**M54 to M6 Link Road  
TR010054**

**8.8 LIU(J) Draft Statement of Common  
Ground with Elizabeth Whitehouse &  
Stella Arblaster**

#### **8.8 LIU(J) Draft Statement of Common Ground with Elizabeth Whitehouse & Stella Arblaster**

Drawing file: TR010054 / TR010054-001020-TR010054 M54 6.3 Figure 2.7 Draft Masterplan Sheet 5 of 5.pdf

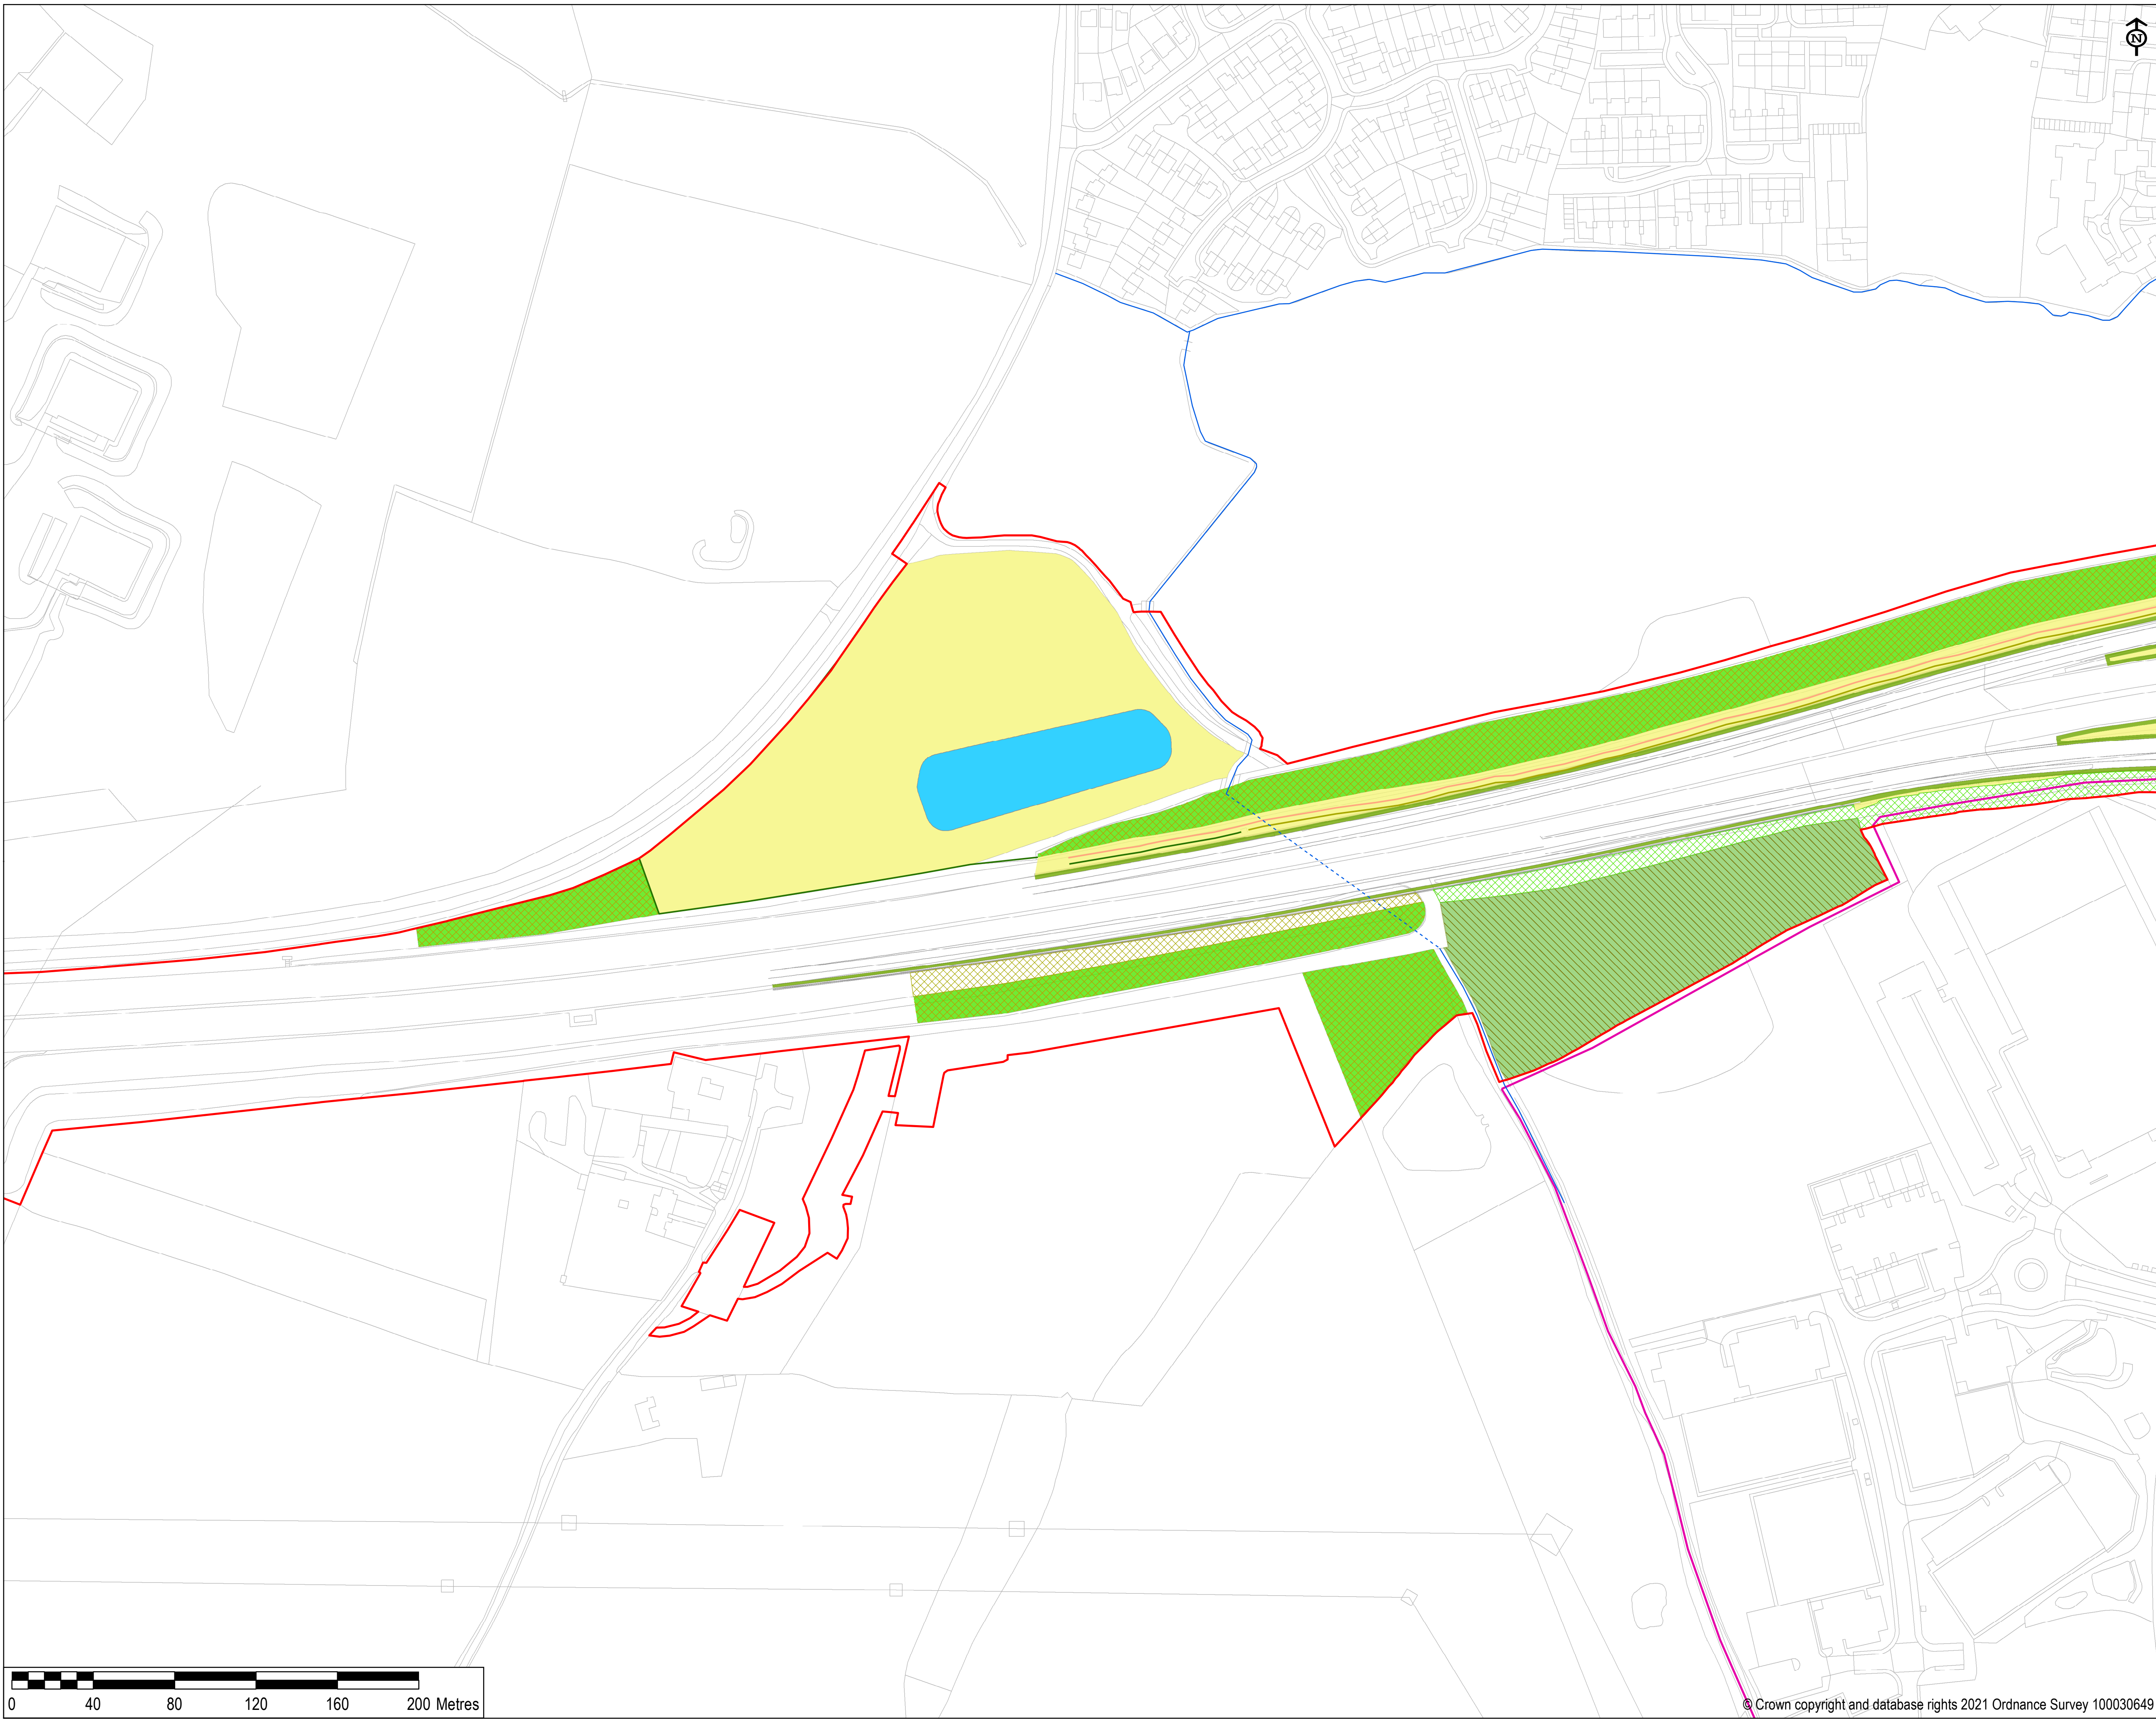
Statement of Reasons [AS-016/4.1]. An updated version of the Statement of Reasons was submitted with a request for Scheme changes on 9 October but this does not alter the proposed uses of this plot.		
	Land agent's response to second draft SoCG issued on 30/10/20	Land agent notes that there has been a reduction of two other third party landowners and suggests Highways England are attempting to appease other landowners and not their client	<p>Following an assessment of the design changes (accepted by the ExA October 2020) and the results of further ecological surveys, Highways England was able to make a number of amendments to the Environmental Masterplan. Highways England disagrees with the statement that other landowners have been given preferential treatment.</p> <p>Those areas where mitigation has been reduced were identified as the most appropriate with mitigation in these locations often providing a single function. Following the design changes reductions in these areas was made possible without worsening the impacts of the Scheme.</p> <p>Plot 6/9 is required for a number of purposes as set out in the technical note provided in August 2020 and Environmental Mitigation Approach [REP1-057/8.11]. The highway drainage pond and woodland planting</p>	Under discussion	Medium

could not be removed or relocated as they would no longer provide their proposed functions.		
	Land agent's Relevant Representation – RR-036	The Project has an excessive area of land take for ecological mitigation with no justification provided.	<p>HE disagrees that the land take for environmental mitigation is excessive. HE considers all mitigation proposed to be essential mitigation and the minimum required for the Scheme. HE has provided information on environmental mitigation and the reasons behind it throughout the development of the Scheme.</p> <p>Mitigation and the justification for land required has been discussed at meetings and is provided in application documents, including:</p> <ul style="list-style-type: none"> <li>• Works Plans [APP-009/2.4];</li> <li>• Statement of Reasons [APP-021/4.1];</li> <li>• Consultation Report, Annex P [APP-039/5.2];</li> <li>• ES, Chapter 8 Biodiversity [APP-047/6.1]; and</li> <li>• Case for the Scheme &amp; NPSNN Accordance Table [APP-220/7.2].</li> </ul> <p>Further detailed information on land owned by Ms Whitehouse and Ms Arblaster was provided in</p>	Under discussion	Medium

<p>documentation issued to the landowner on 16 July 2020. This Technical Note describes the rationale behind essential mitigation proposals in respect of the M54 to M6 Link Road (the Scheme) on land covered by an interest of Elizabeth Whitehouse and Stella Arblaster as proposed in Figures 2.1 to 2.7 of the ES [APP-057 to APP-063/6.2]. A mix of new woodland planting, hedgerows, species-rich grassland and amenity grassland are to be created on this land to mitigate the loss of ancient woodland and habitat at Brookfield Farm SBI and the loss of habitat for GCN and bats. Woodland planting and grassland is also required to provide landscape integration and improve visual amenity.</p> <p>The amount of land required for environmental mitigation will not change following the accepted Scheme changes submitted on 9 October to the Examining Authority.</p>		
	Landowners' response to review of 'Environmental Mitigation	We note that Highway England approach to measuring the population of GCN's within the area has been extremely cautious and appears to significantly	A distance of 500m from the Scheme boundary was used to identify ponds and terrestrial habitat which could be affected by the construction and operation of the Scheme. This is in line with Natural	Under discussion	Medium

<p>Approach' following RR-36</p>	<p>overestimate both the number and size of GCN breeding populations within 500m of the road, which we understand is double the required distance.</p> <p>We understand your surveys have indicated that there is GCN presence has been found in only three of the 28 waterbodies that were surveyed, equating to less than 11% of the ponds sampled for GCN DNA.</p>	<p>England Great Crested Newt Mitigation Guidelines (2001) which identifies a distance of up to 500m from a site as being the criteria for undertaking surveys for great crested newts and identifies the area of terrestrial habitat up to 500 m around a pond as potential newt habitat. Natural England's Method Statement Template for licensing (April 2020) also refers to the need to undertake surveys at distances beyond 250 m when certain criteria are met. In this instance all the criteria were met to warrant surveys beyond 250m. This issue was discussed in greater detail at Issue Specific Hearing 1 on 8 December 2020, the recording of which can be listened to on the Planning Inspectorate website <a href="https://infrastructure.planninginspectorate.gov.uk/projects/west-midlands/m54-to-m6-link-road/?ipcsection=docs&amp;stage=4&amp;filter1=Recording+of+hearing">https://infrastructure.planninginspectorate.gov.uk/projects/west-midlands/m54-to-m6-link-road/?ipcsection=docs&amp;stage=4&amp;filter1=Recording+of+hearing</a>.</p> <p>The Scheme changes accepted by the ExA on 29 October 2020 reduced the environmental mitigation proposed. This reduction in land has been possible due to completion of</p>

<p>further ecological surveys and revision of the mitigation strategy. Surveys undertaken in 2020 showed that ponds previously assumed to support great crested newts (GCN) on a precautionary basis, were unlikely to support the species. This allowed for the removal of four mitigation ponds and associated terrestrial habitat based on the 2020 survey results.</p> <p>It is standard practice to adopt a precautionary principle and assume populations of GCN in ponds where survey access has not been possible. This demonstrates that the Scheme is licensable should GCN be found to be present at a later date. Though the Environmental Masterplan still includes mitigation for the impact on GCN as set out in Environmental Mitigation Approach [REP1-057/8.11], none of the mitigation measures illustrated on the Environmental Masterplan [AS-086/6.2] are required for the sole purpose of mitigating impacts on GCN.</p>

on ancient woodland, but there remains an impact due to construction within the buffer areas around ancient woodland and due to air quality impacts. There is no reduction in the area needed for compensation on land owned by EW and SA.		
Identification of ancient woodland	Landowners' response to draft 2 of SoCG issued on 30/10/20 concerning the identification of ancient woodland	Our clients disagree with the 'identification' of ancient woodland at Brookland Farm as we understand this is an area of relatively young trees, they feel the explanation given is unsatisfactory and would be grateful if more evidence could be provided to support this claim.	The area of woodland referred to is recorded on the 1842 OS map and is shown as being continuously wooded from that point onwards. No earlier maps of this area are available. However, with the landform recorded (an increasingly steep ravine) and cohort of woodland flora present this area is considered likely to be ancient woodland. This was discussed and agreed with Natural England as recorded in our Statement of Common Ground with Natural England [APP-221 and subsequent revisions].	Under discussion	Medium
